**Consultation Response from KC,  
Highways Development Management****2025/90931 adj, 258, Wakefield Road, Denby Dale, Huddersfield, HD8 8SU****Erection of dwelling with detached garage and associated external alterations****Date Responded: 29/07/2025.****Responding Officer: D. Stainsby****Responding Ref: K17-21/6**

This application is for the erection of a dwelling with detached garage and associated external alterations.

Proposed Site Plan
Scale 1:250

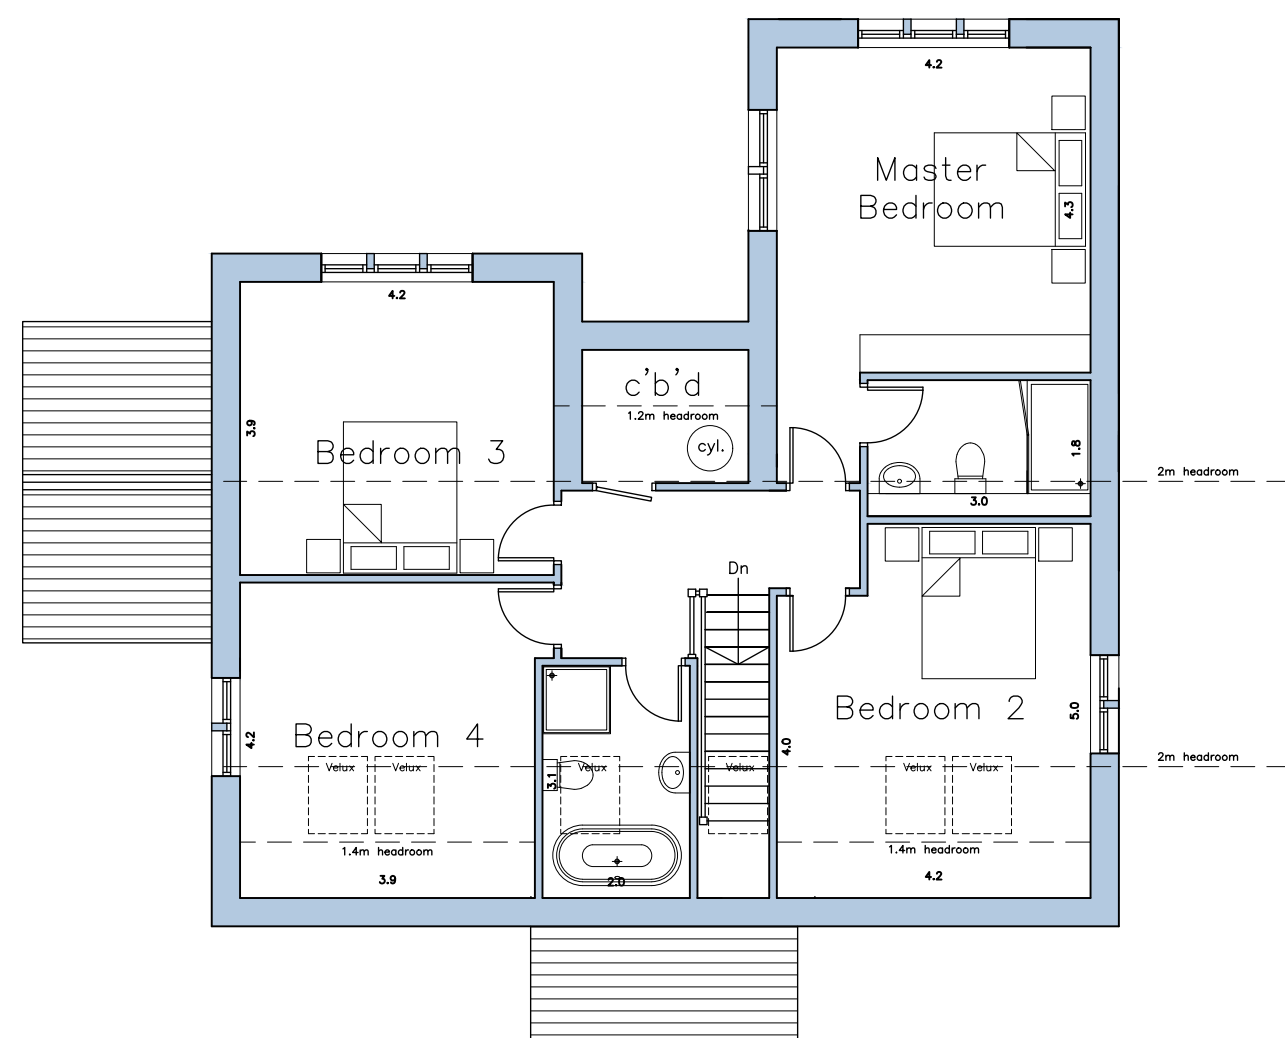
The Applicant states that bin storage will be kept within each property with the bin collection point to remain as it currently is, at the bottom of the driveway off Wakefield Rd. However, no bin storage areas are shown.

A bin collection/presentation point should be located adjacent to the public highway. The bin collection/presentation point must not obstruct the adopted highway or the access road.

Details of waste storage and collection should be provided, with the location of a waste collection presentation point being clearly marked on a drawing in such a location that is easily accessible to the collection team and where it will not obstruct the parking, access or the adopted highway for road safety reasons.
